WEST SUSSEX COUNTY COUNCIL CONSULTATION

TO:	Arun District Council FAO: Amber Willard
FROM:	WSCC - Highways Authority
DATE:	7 January 2021
LOCATION:	14 East Bank North End Road Yapton BN18 0DJ
SUBJECT:	Y/121/20/HH Installation of a dropped kerb
DATE OF SITE VISIT:	n/a
RECOMMENDATION:	More Information
S106 CONTRIBUTION TOTAL:	n/a

Proposed Plan - 1:100 @A1

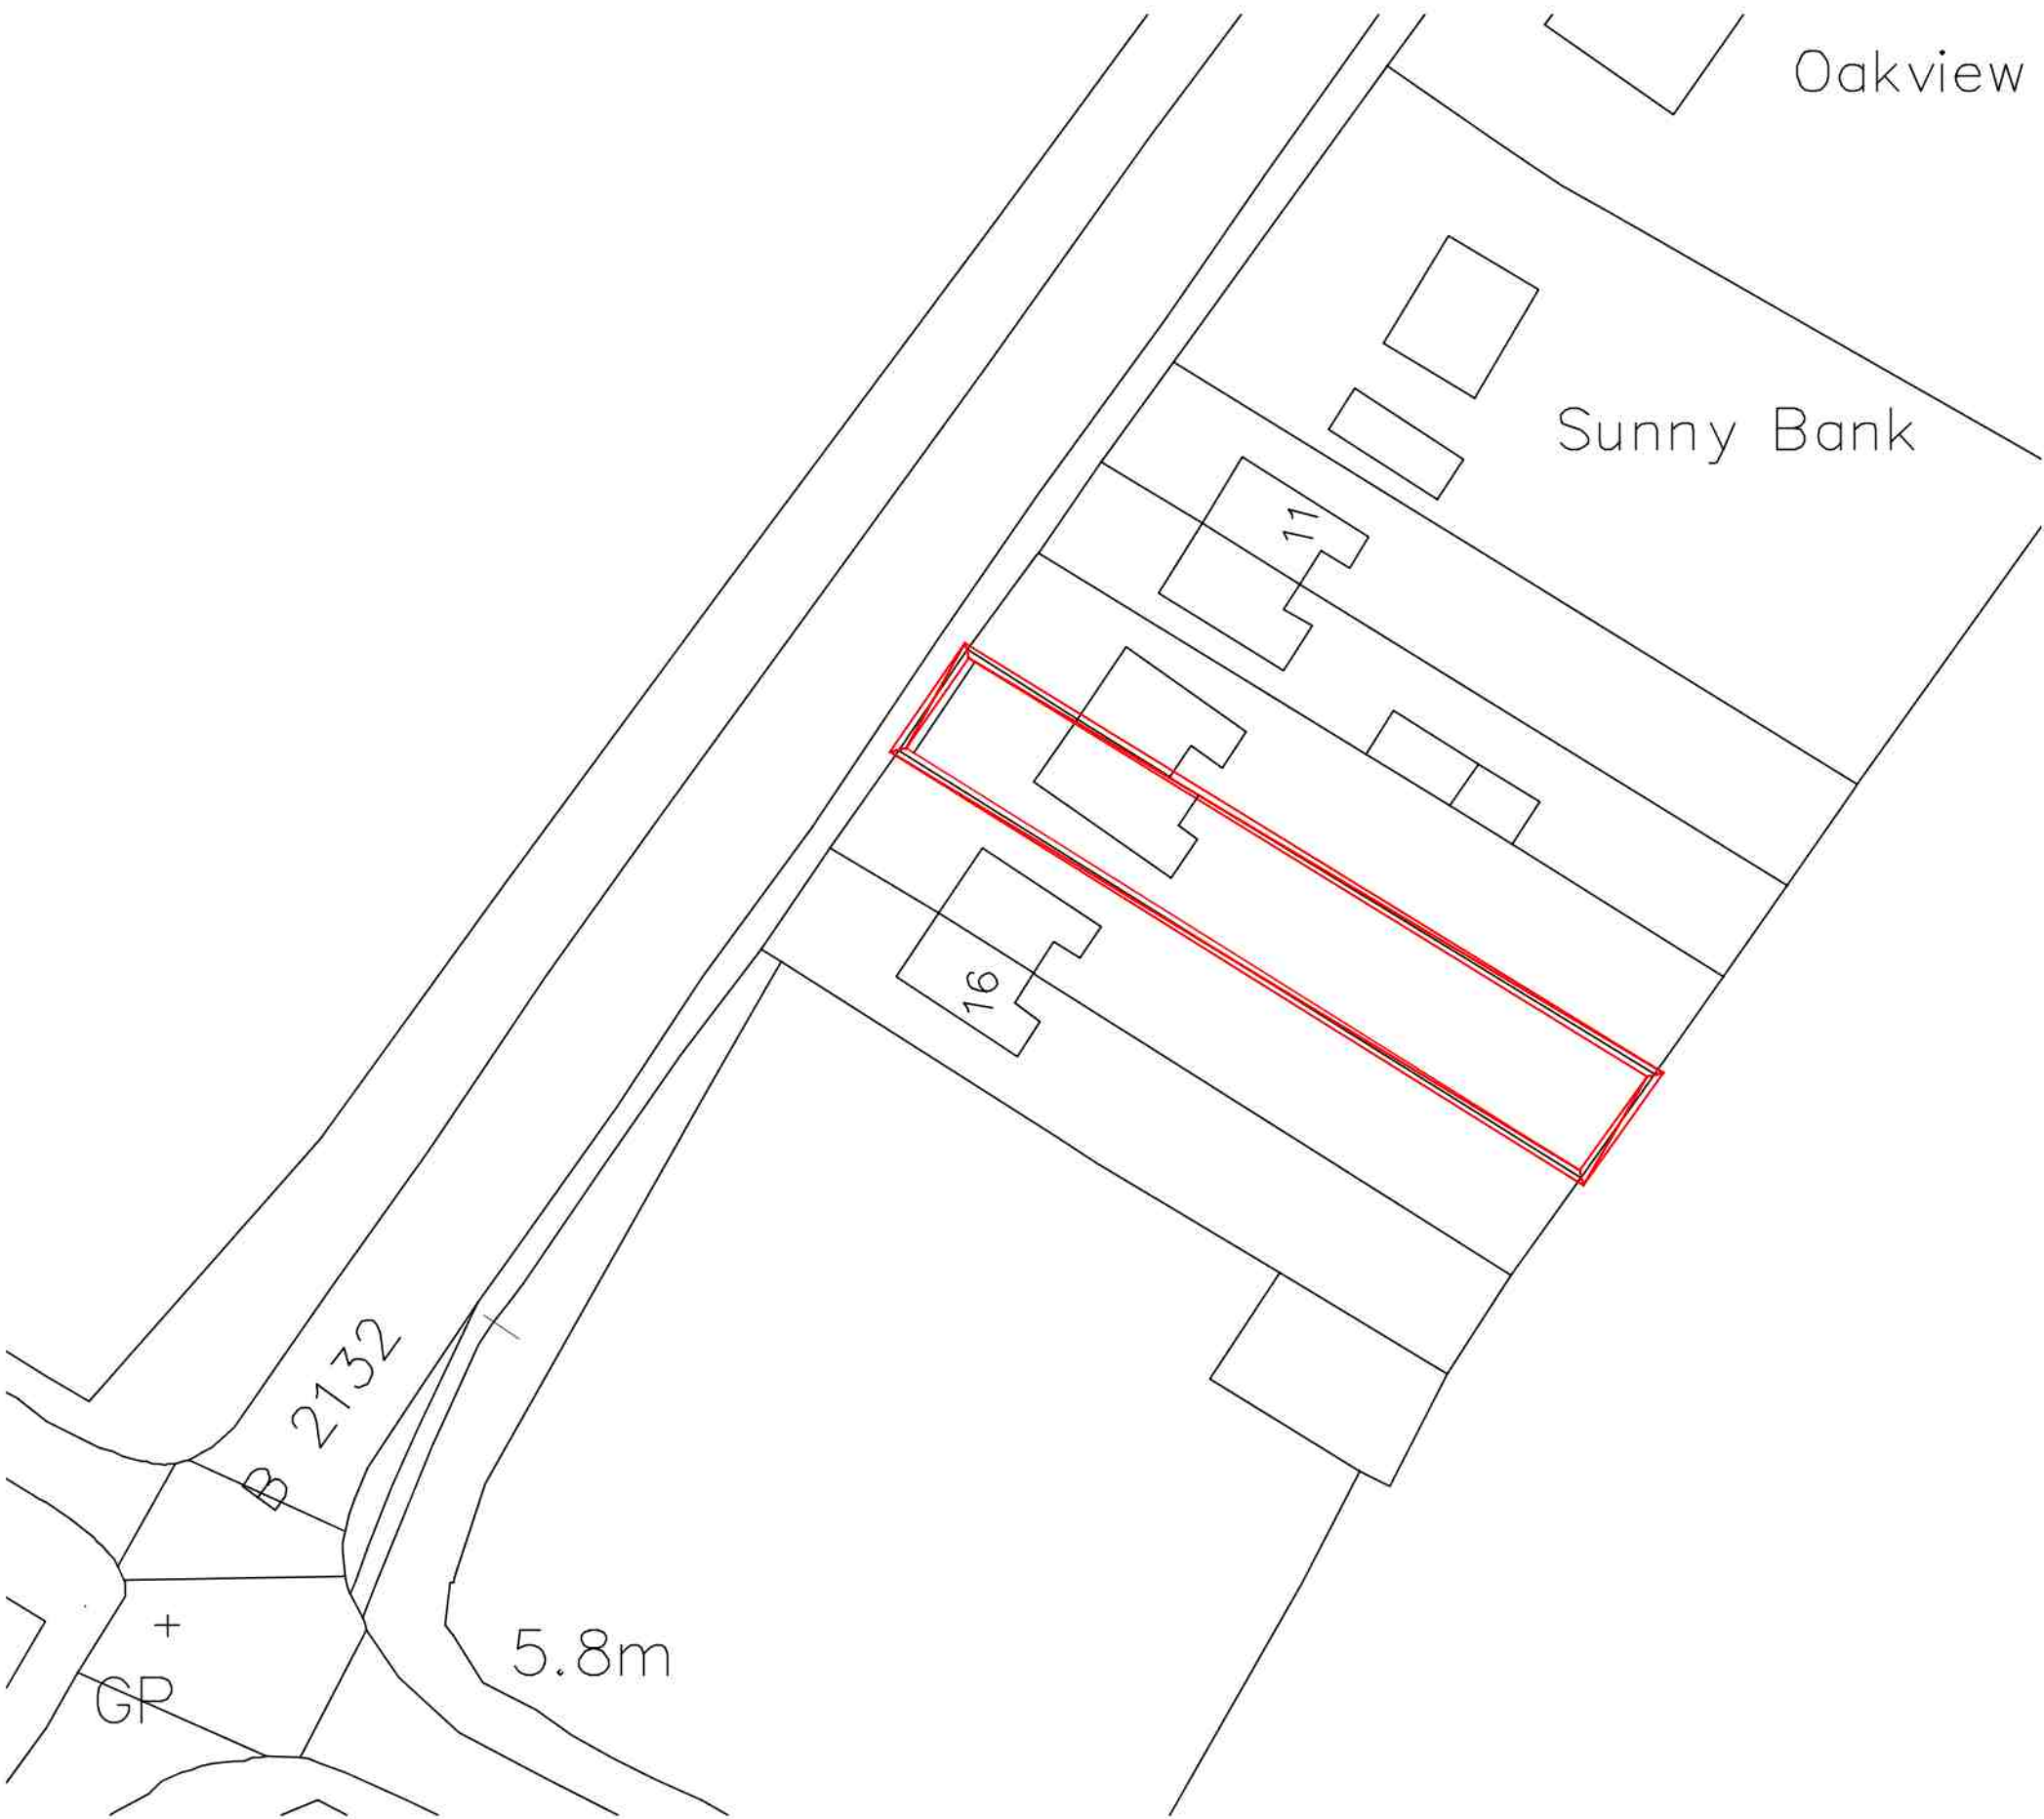
1. Visibility splays crossing 3rd party land,
2. The access proposed is 6.42 metres.

1. The LHA requests that the applicant demonstrates maximum visibility splays that only cross land under the applicants control or within the publicly maintainable highway.
2. The applicant should be made aware that VCO's under 4.5 metres or over 6.4 metres are generally not accepted at the licensing stage. Though in this instance, such a provision is not considered a highway safety concern. The applicant should be mindful that this may result in, if successful, a planning permission that cannot be implemented. Therefore, the applicant is recommended amending the plans to show a kerbside VCO of between 4.5 – 6.4 metres (including transitional kerb stones). Also, the LHA wish to state that VCO's normally are wider at the kerbside and taper back towards the driveway to assist in ease of access.
